Kings Park Metal Recovery and Recycling Facility Expansion (SSD-10396)
Request for additional information

I refer to the Response to Submissions (RTS) for the Kings Park Metal Recovery and Recycling Facility Expansion (SSD-10396). The Department has reviewed the document and notes there continue to be outstanding matters that need to be addressed.

Attachment 1 – Department's comments

Attachment 2 – Noise – Department's comments

Figure 7 – Operational noise contours for evening period with combined worst case adverse meteorological enhancement, $L_{Aeq, 15min}$

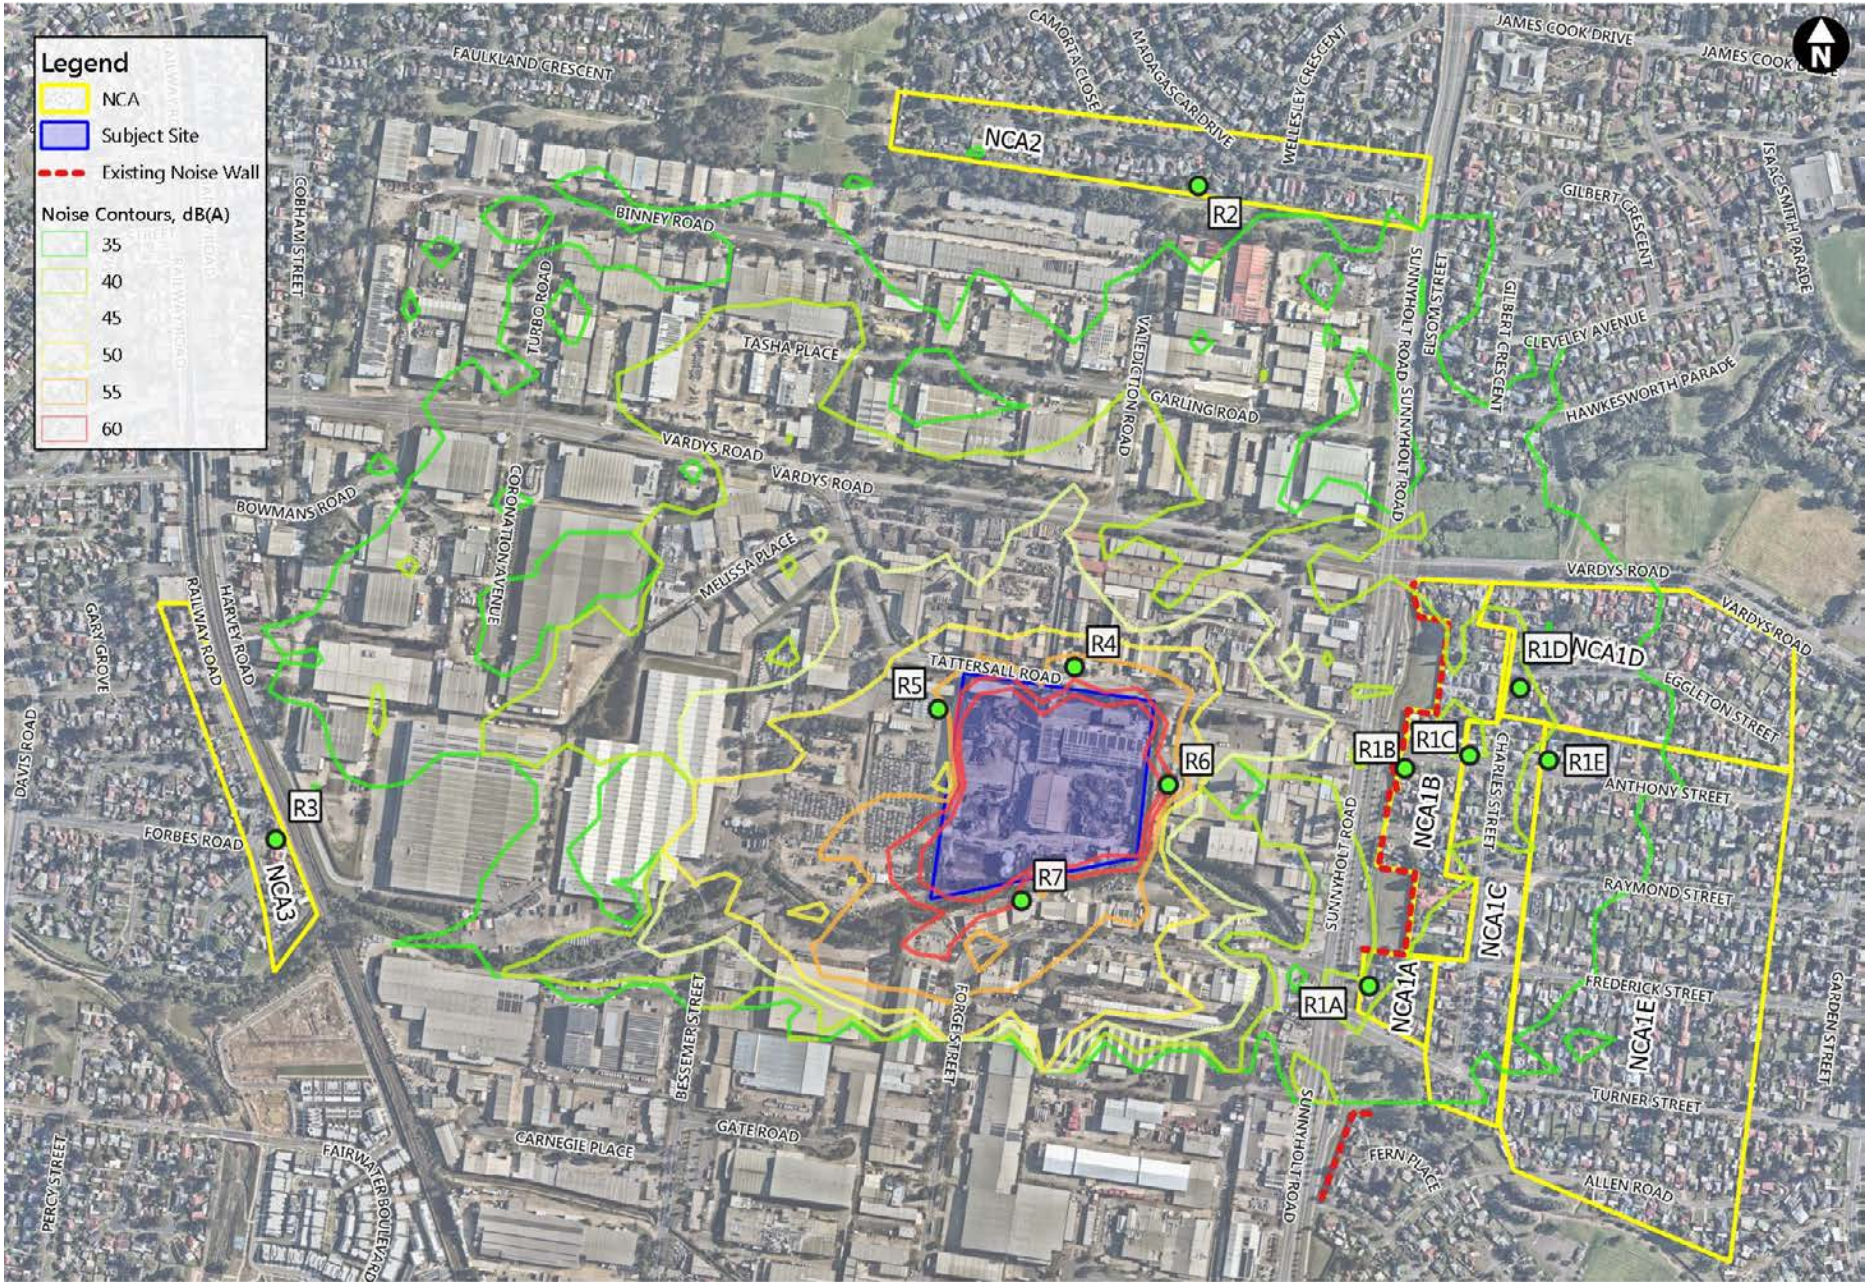
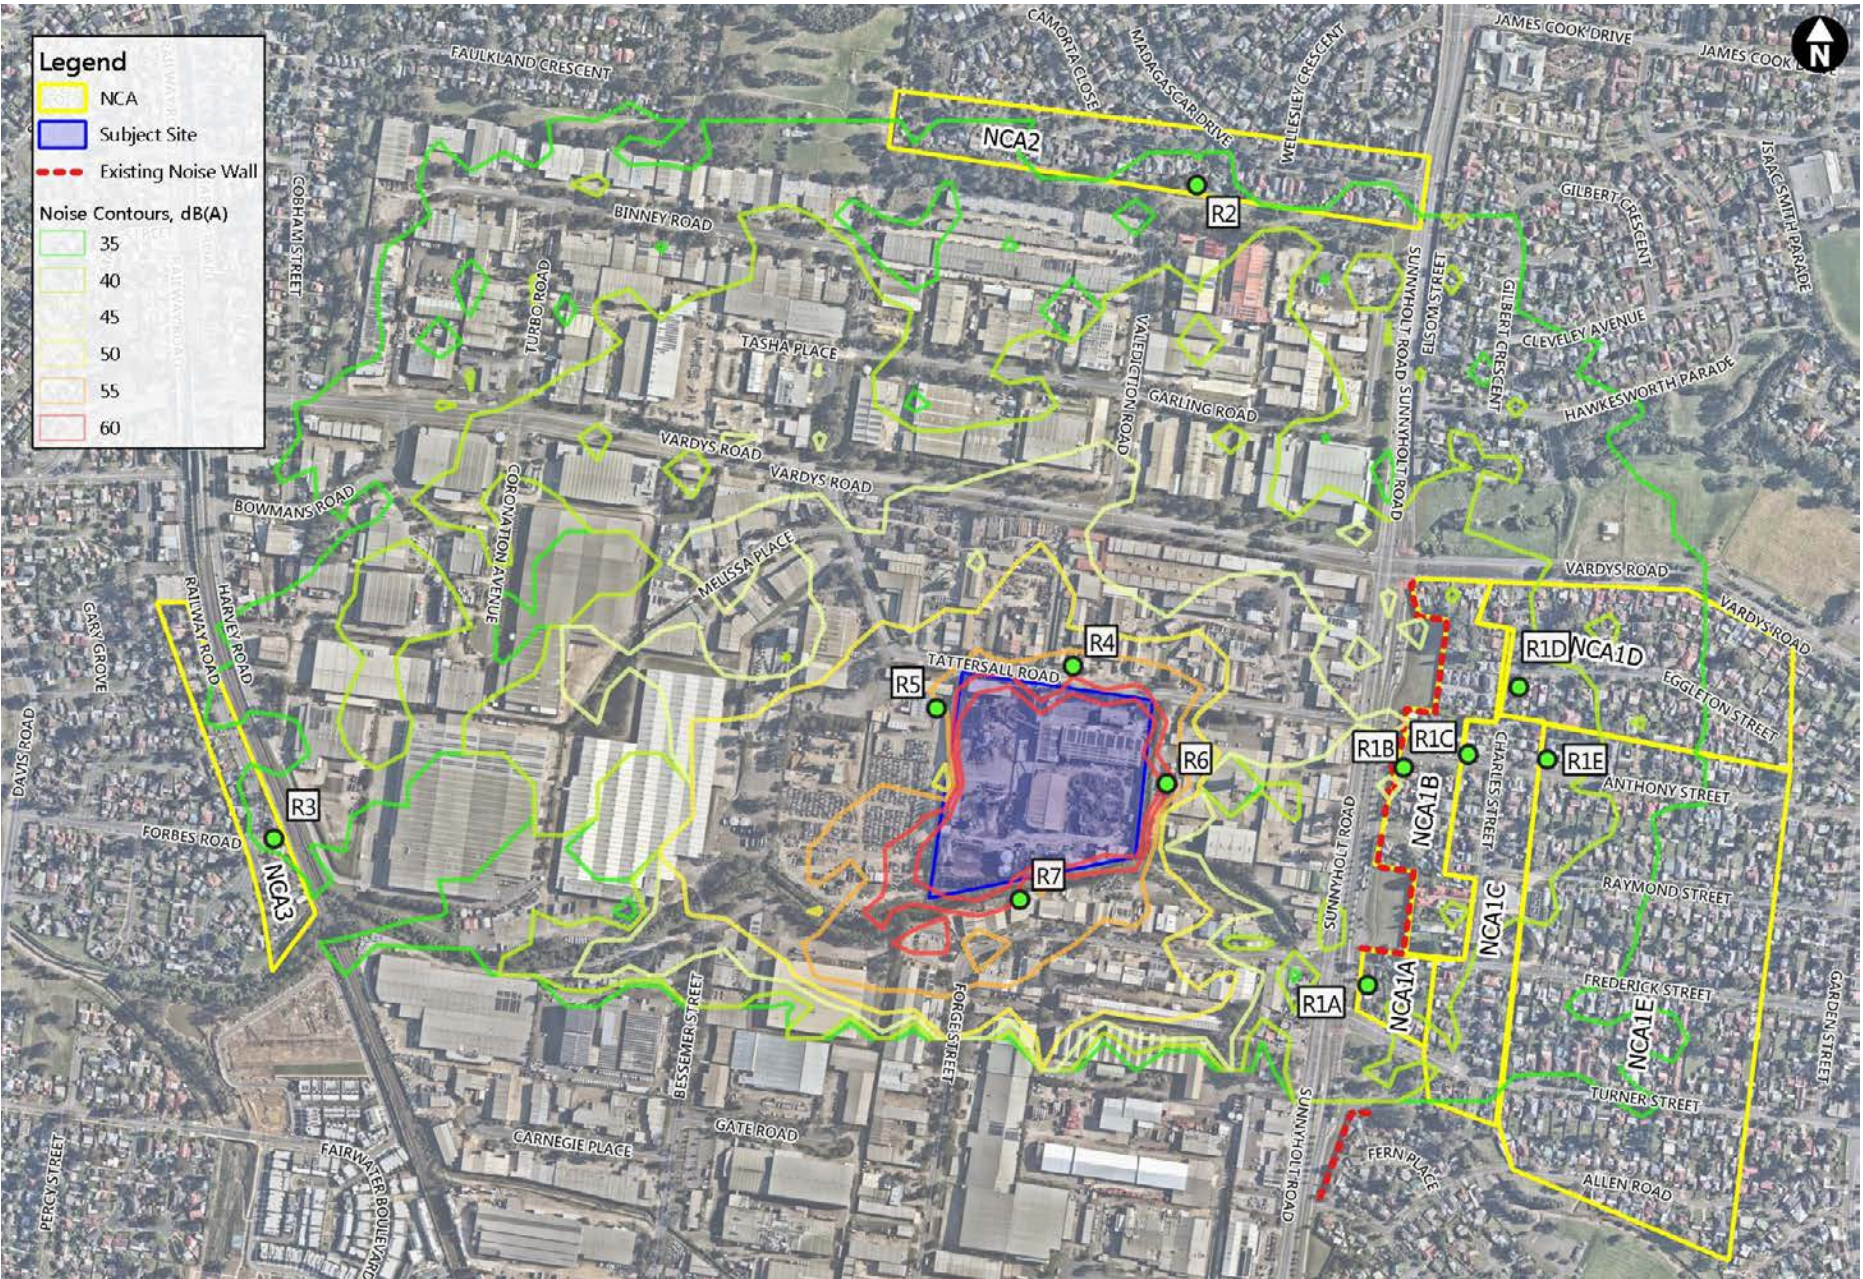
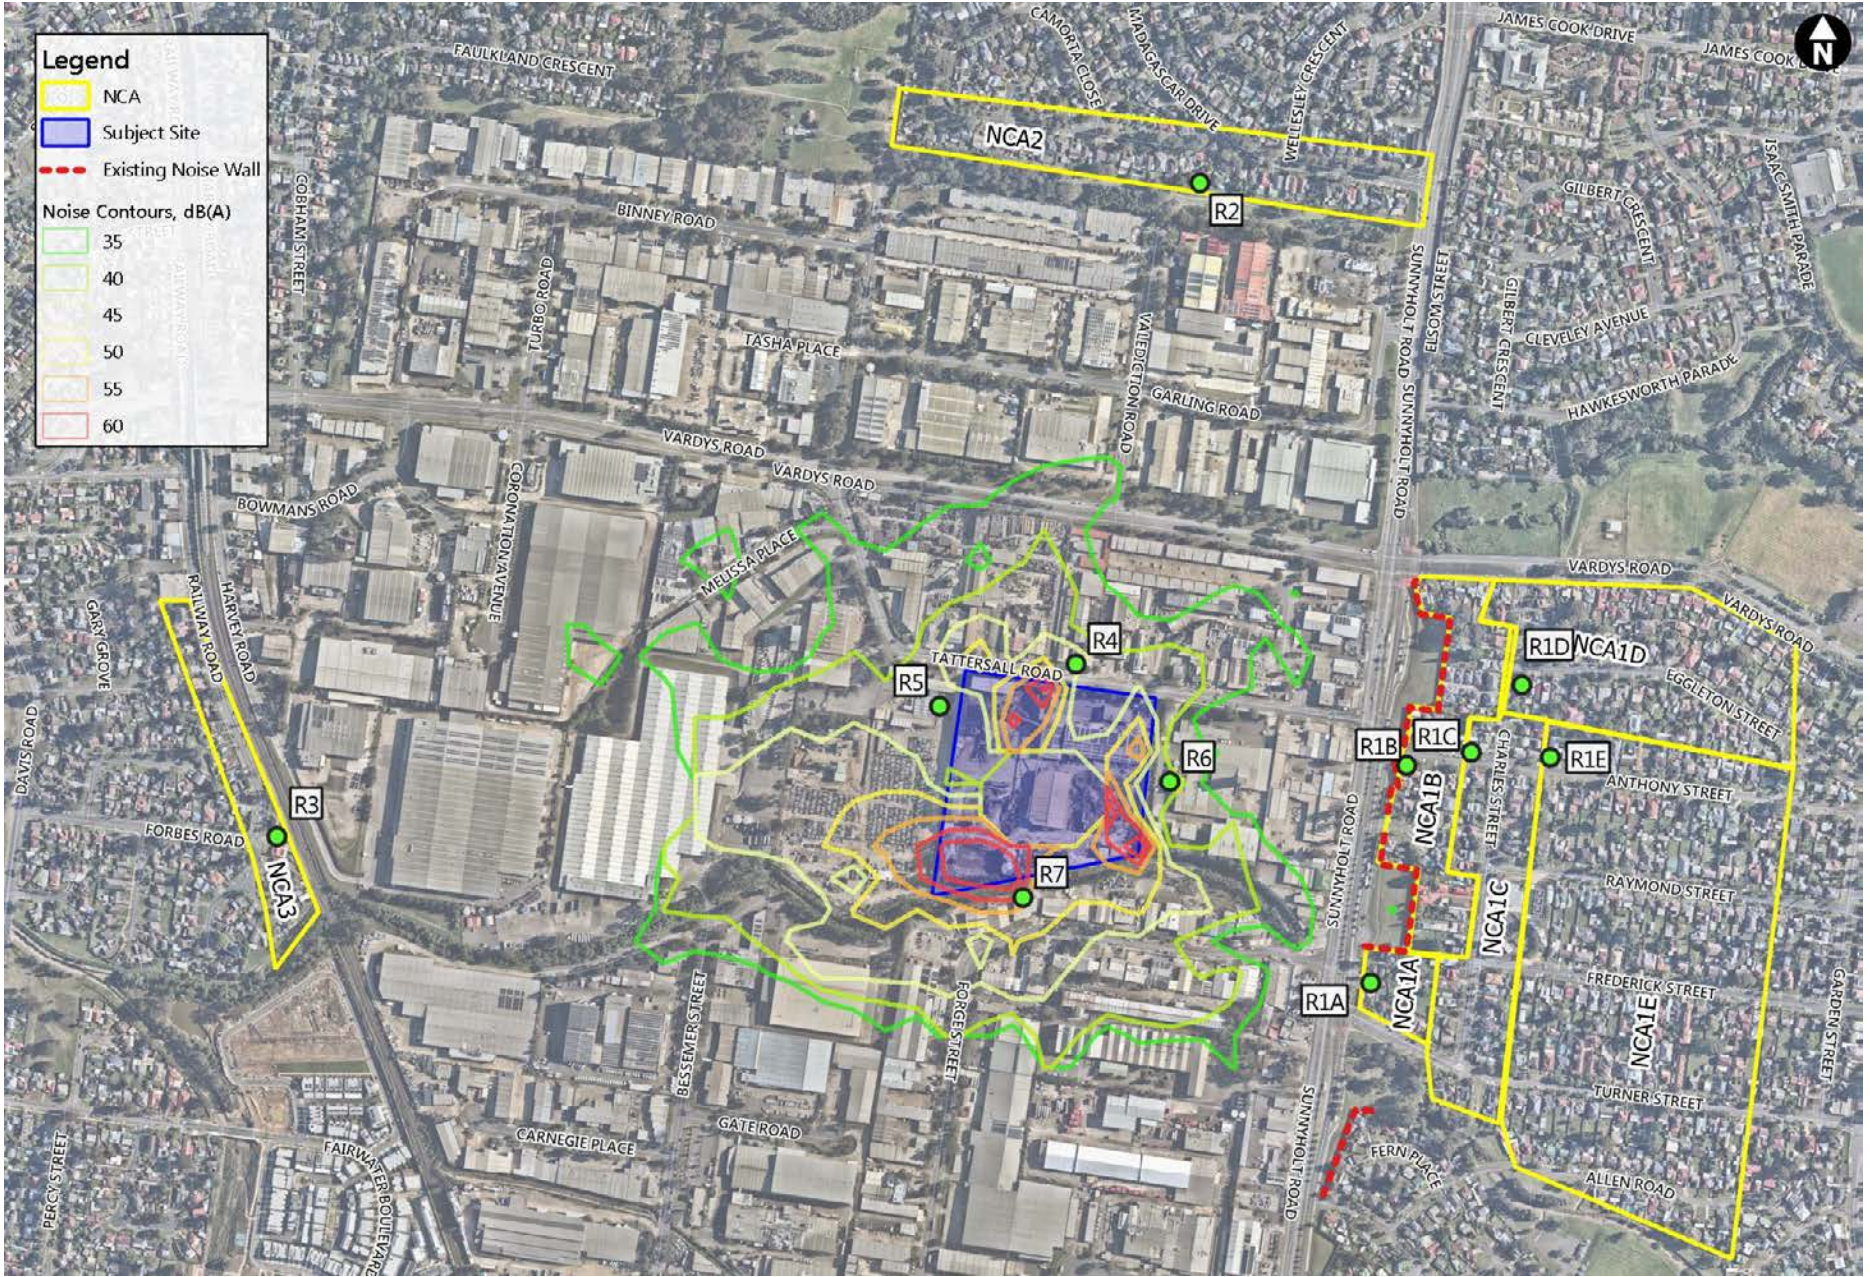
The Department requires additional background noise monitoring data be provided at a representative location along Anthony Street, east of 16 Anthony Street, Blacktown. In addition, operational noise contours must be updated to include all residential receivers from Sunnyholt Road to the highest location above sea level along Anthony Street, covering an assessment radius of no less than 700 metres from the eastern site boundary.

2. Operational noise survey and modelling
- Noise contours shall be updated to display a single decibel value instead of a range of decibel values for each contour line (see **Figure 1**).
